**Our Case Number:** ABP-319566-24

**Re:** The proposed development will comprise of a 600MW Powerplant, 120MW Battery Energy Storage System, Above Ground Installation and associated ancillary works.  
Located within the townlands Kilcolgan Lower and Ralappane between Tarbert and Ballylongford Co. Kerry. ([www.steppowerplant.com](http://www.steppowerplant.com))

Our Ref: CAS-03103Z1B1

**Re: The proposed development will comprise of a 600MW Powerplant, 120MW Battery Energy Storage System, Above Ground Installation and associated ancillary works and is located within the townlands Kilcolgan Lower and Ralappane between Tarbert and Ballylongford, Co.Kerry (Ref: ABP-319566-24).**

SHANNON LNG LIMITED SHANNON TECHNOLOGY AND ENERGY PARK (STEP) GRADING AND DRAINAGE - SITE PLAN - AREA 5		PROJECT 198291-1STF-S3005	DRAWING NUMBER 2
CODE	AREA

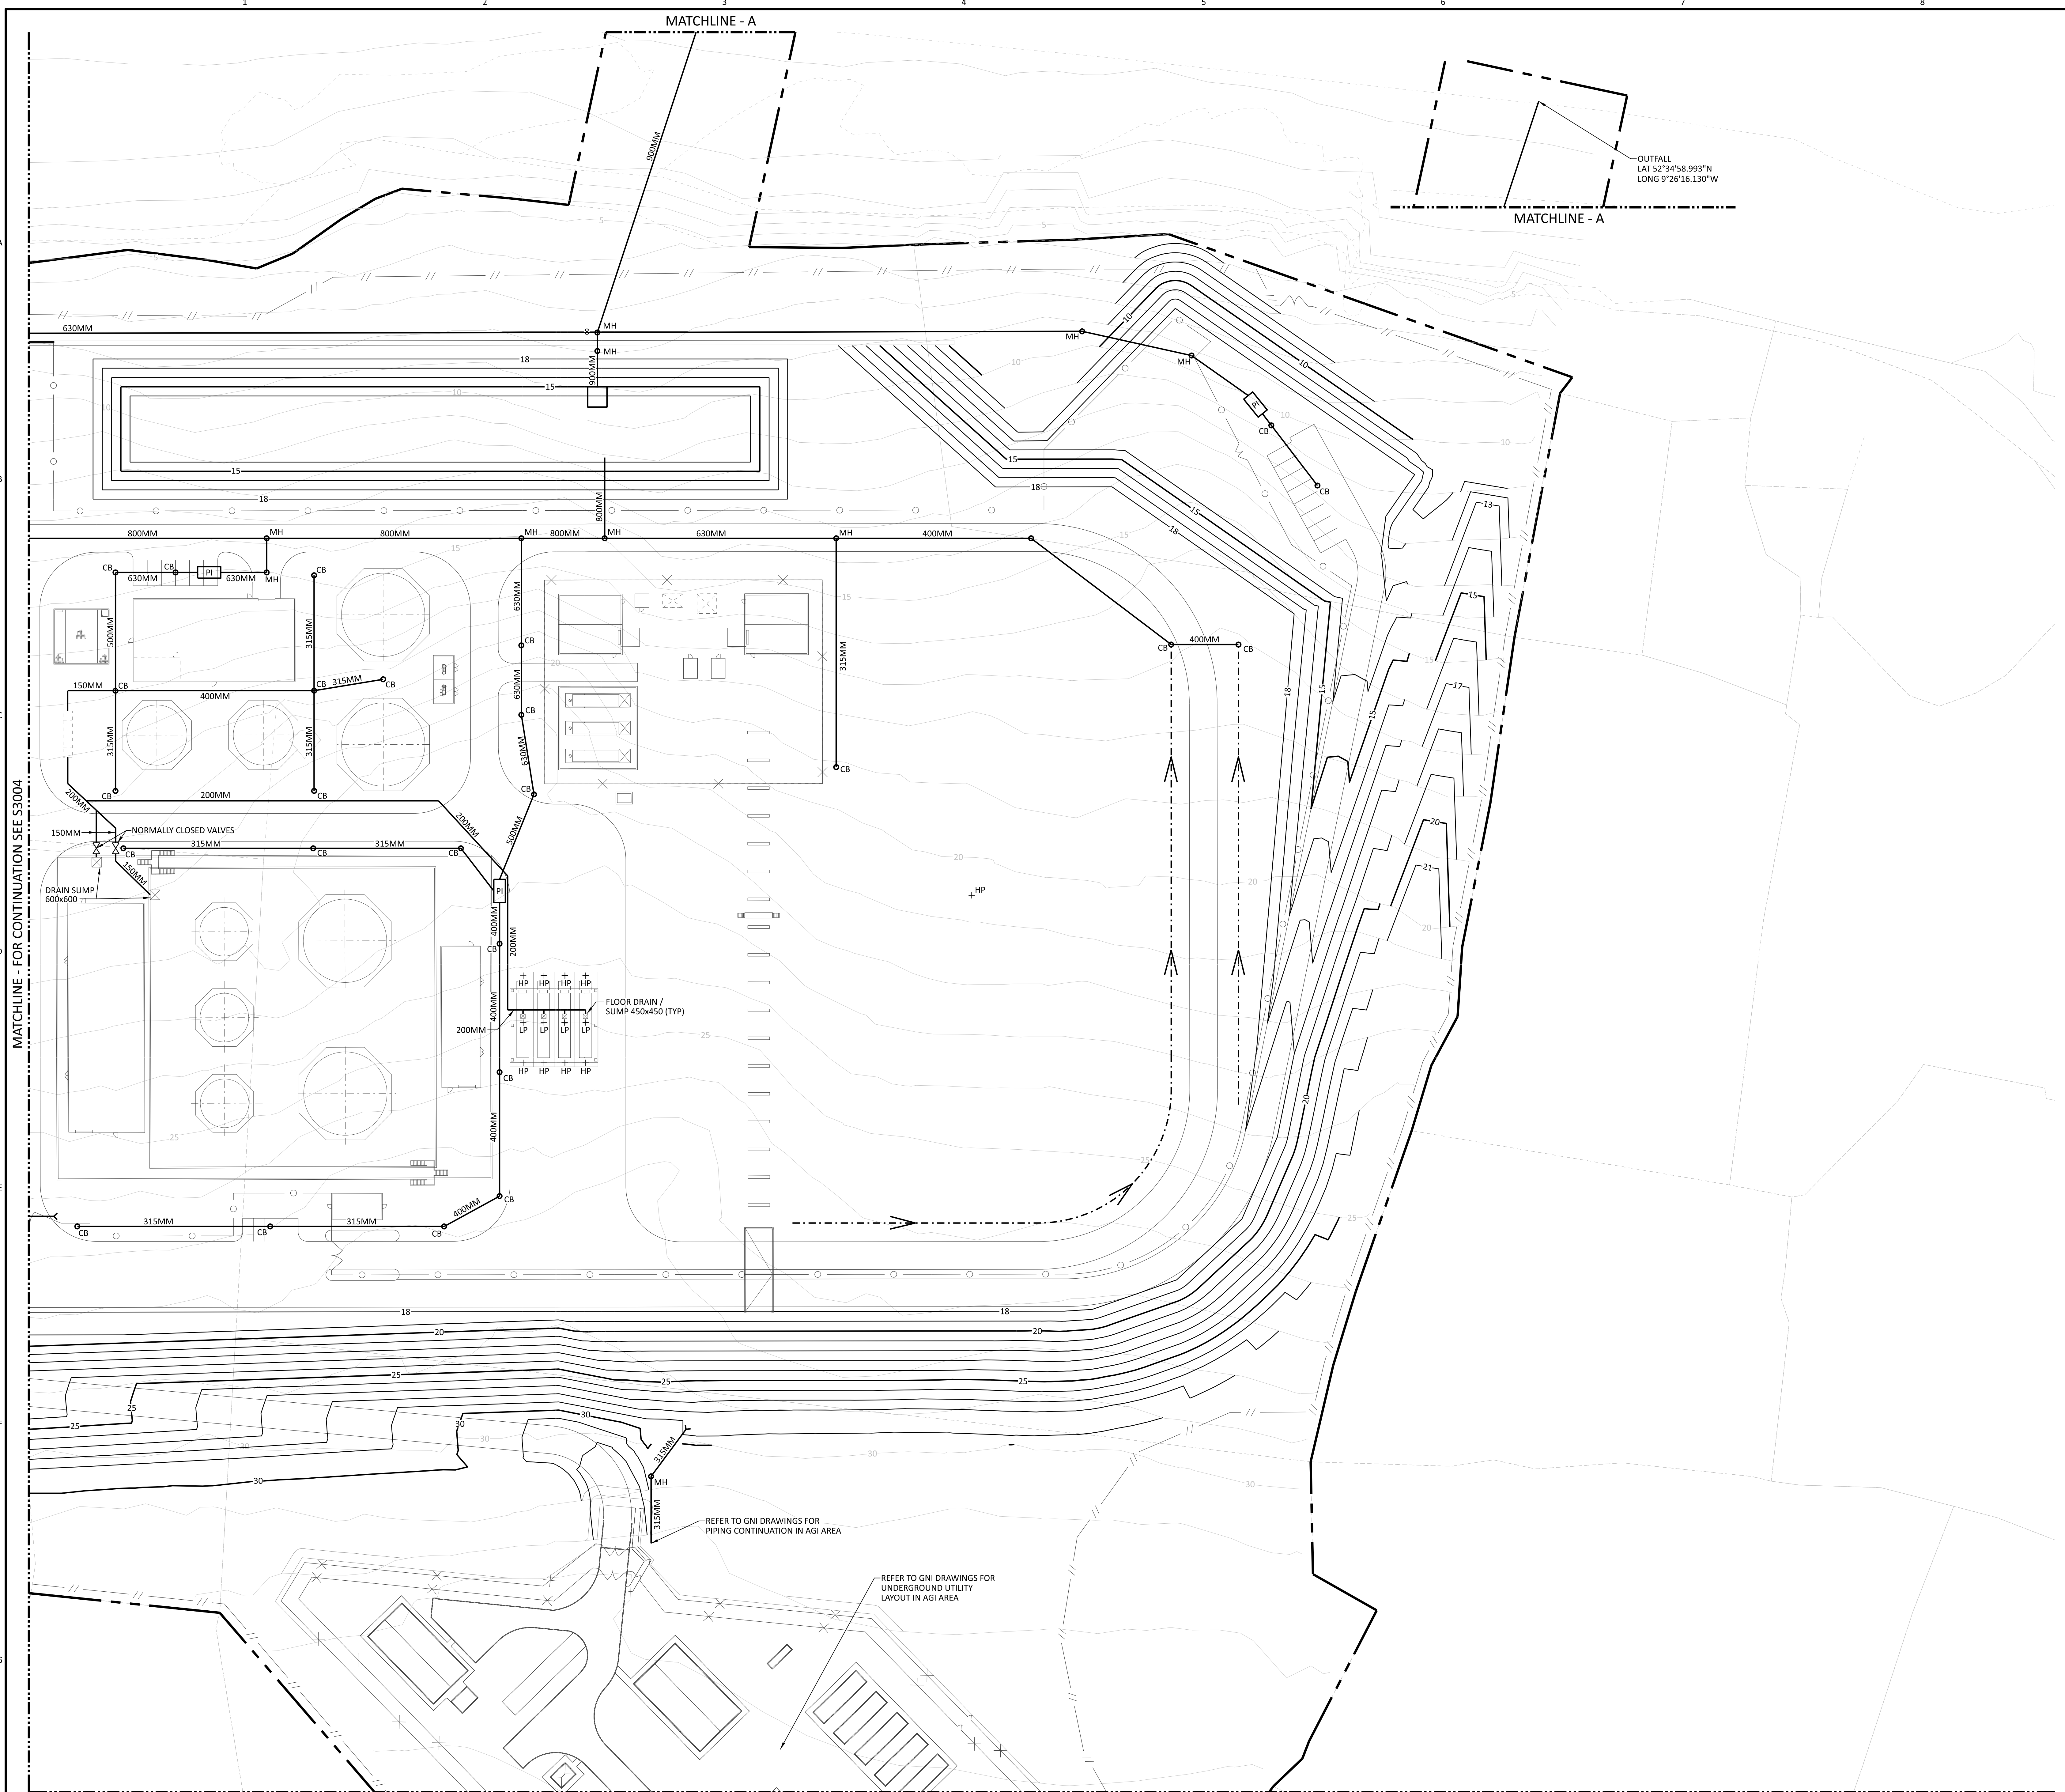
2. Provide further details on spill management and containment arrangements at the distillate tanker unloading area. It is the Authority's understanding that the tanks will be filled by road tanker as there is no reference to a jetty.
